**Consultation Response from KC,
Highways Development Management****2025/91905 Land at, Woodhead Road, Honley, Holmfirth, HD9 6PU****Erection of temporary veterinary surgery and associated works****Date Responded: 18/09/2025****Responding Officer: CNB****Responding Ref: K3-49/2**

DRAWING No: 2504302	REV: P03
------------------------	-------------

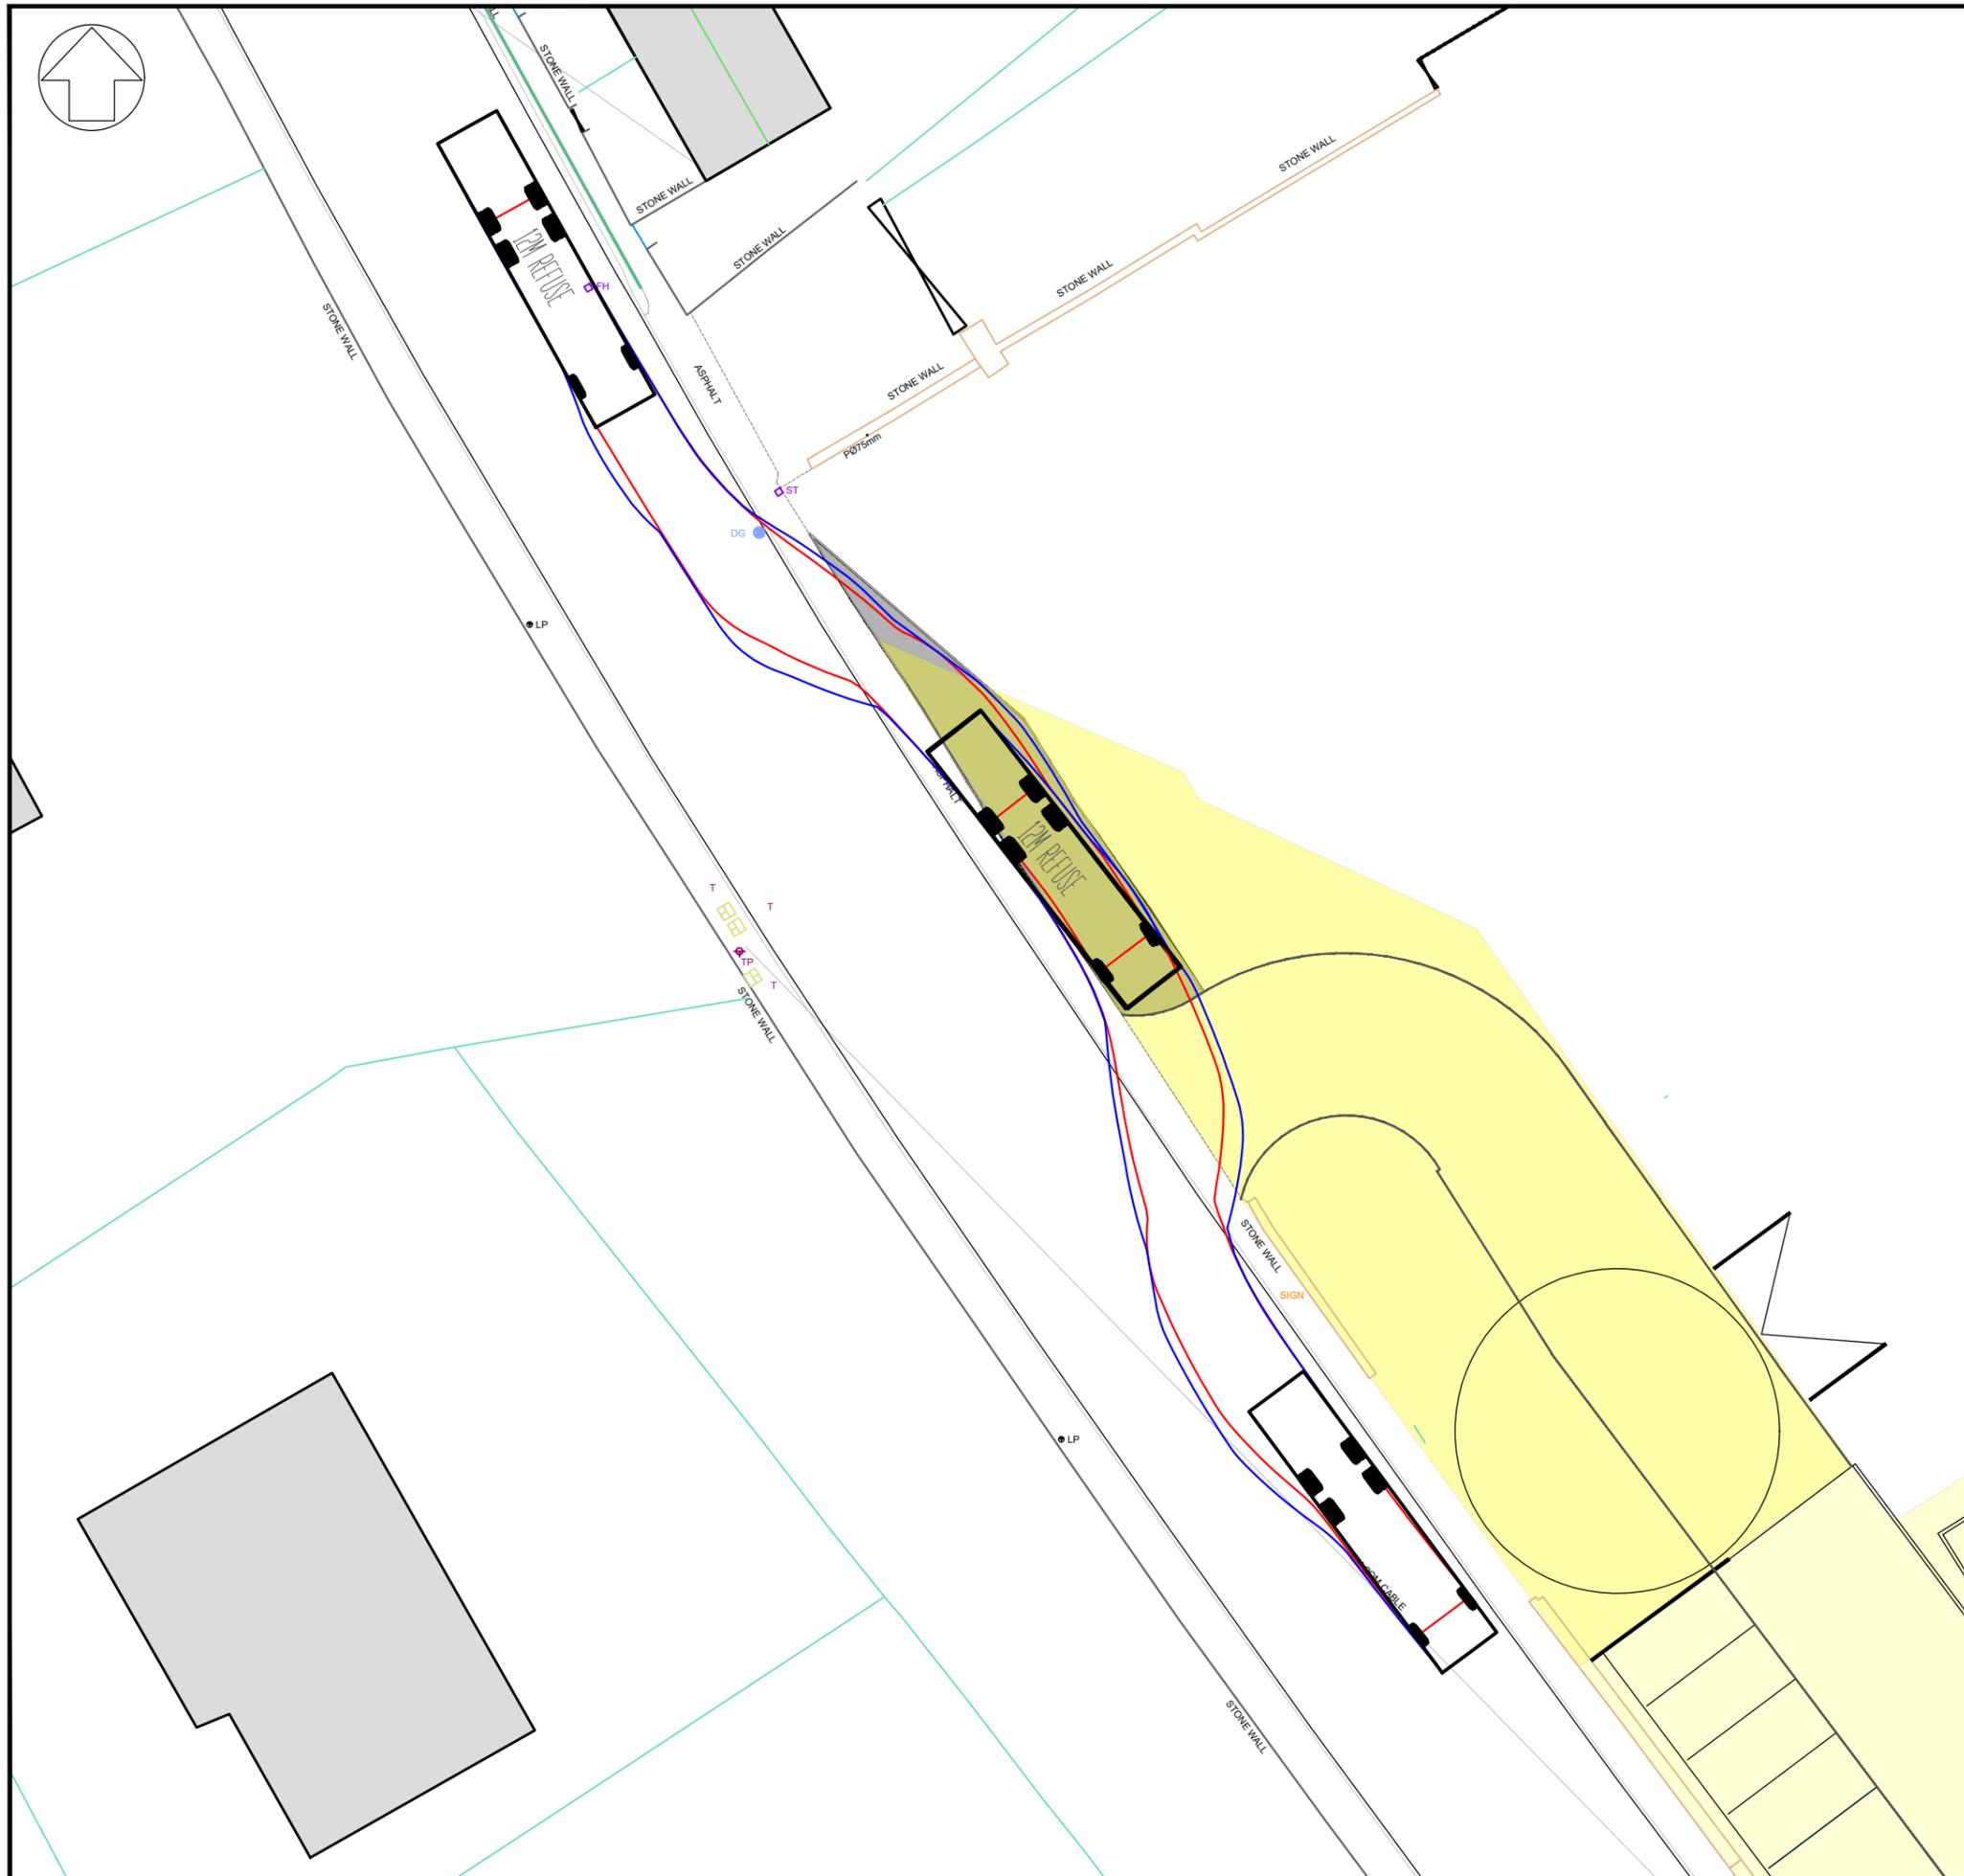
Drawing No 2504303 Rev P03 shows a swept path analysis indicating that a large car can safely enter and exit the site and can access the parking spaces and turn within the site to allow entry and exit in forward gear. Drawing No 2504302 Rev P03 shows a swept path analysis for waste collection at the site and indicates a 12m refuse wagon can safely access the site for waste collection. It is assumed that, when not in use for waste collection, the space indicated on drawing No 2504302 Rev P03 can also be used for large deliveries for the construction of the veterinary hospital.

DRAWING No: 2504301	REV: P03
------------------------	-------------

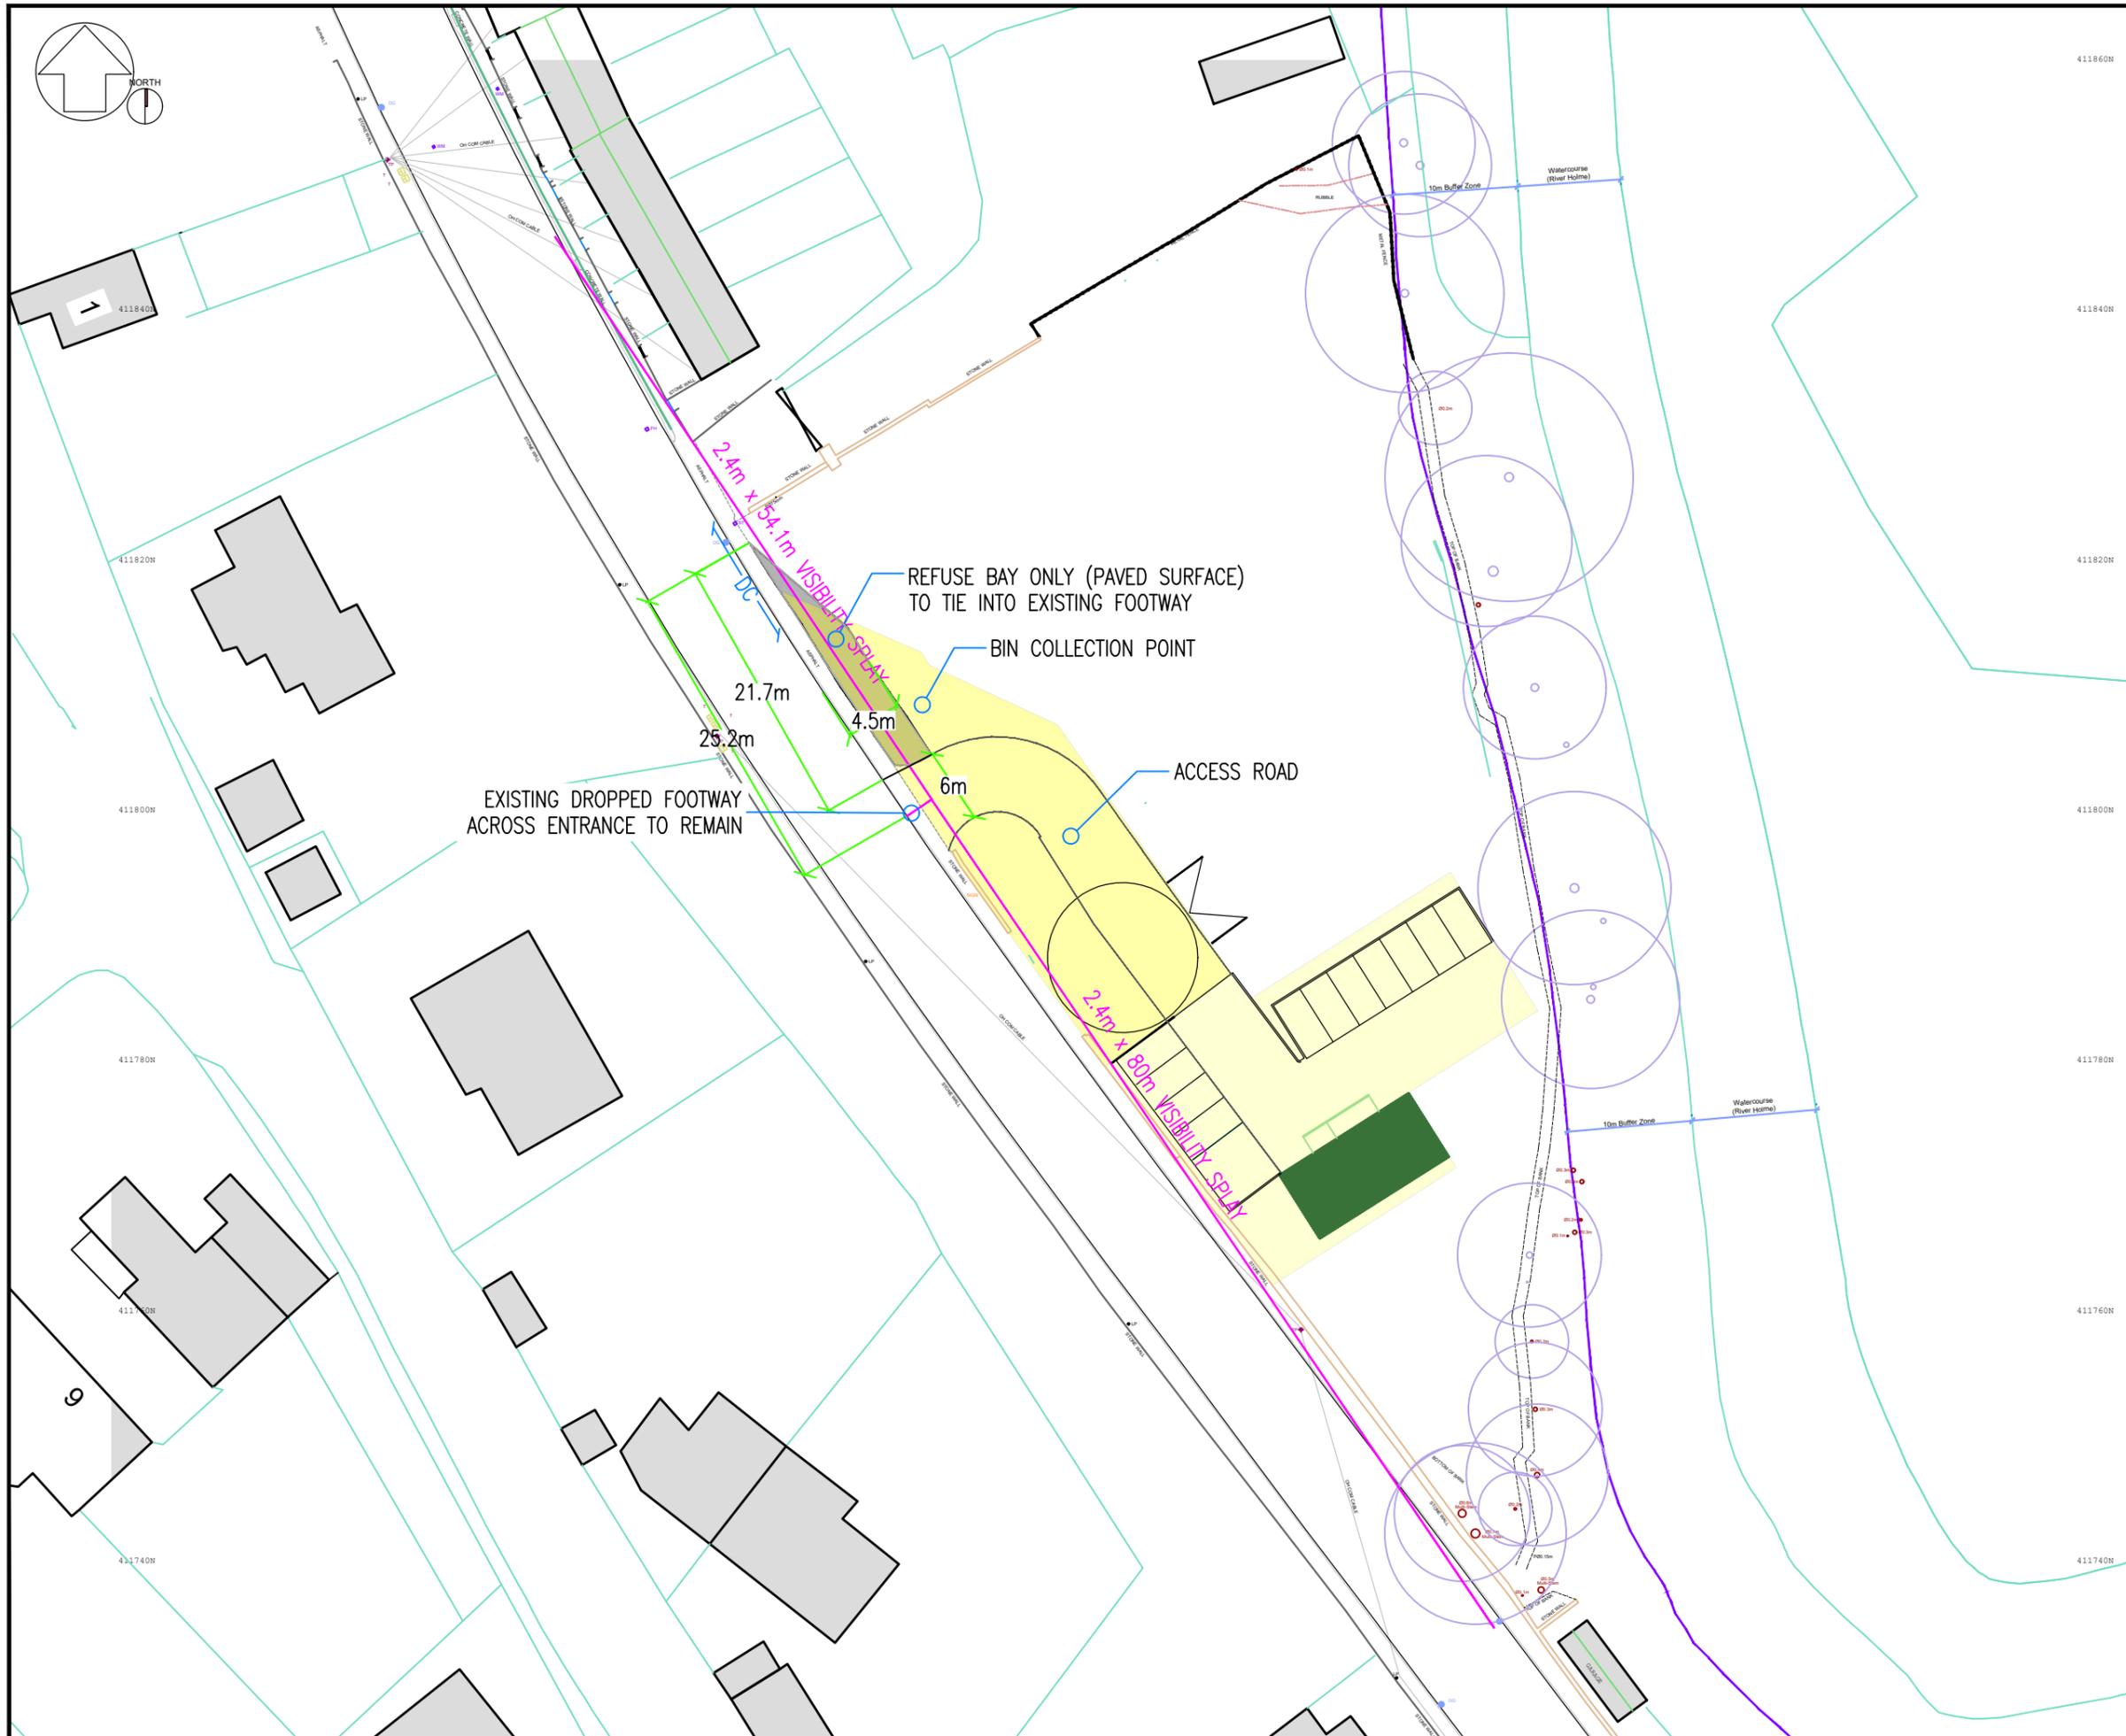
Drawing No 2504301 RevP03 shows the proposed layout of the temporary access as being 6m wide and with a 4m radii curve. Visibility splays of 2.4m x 54m to the right and 2.4m x 80m to the left are shown as being achievable. These visibility splay y-lengths are acceptable given the submitted speed survey 85th percentile results of 33.1mph northwest-bound and 34.9mph southeast bound (as provided in Appendix A of the Highways Note).

Waste storage is shown on drawing No. 1101 Rev9 adjacent to the temporary building and cycle parking and a temporary waste collection point being shown adjacent to the proposed temporary access on drawing No 2504301 RevP03 and these are acceptable.
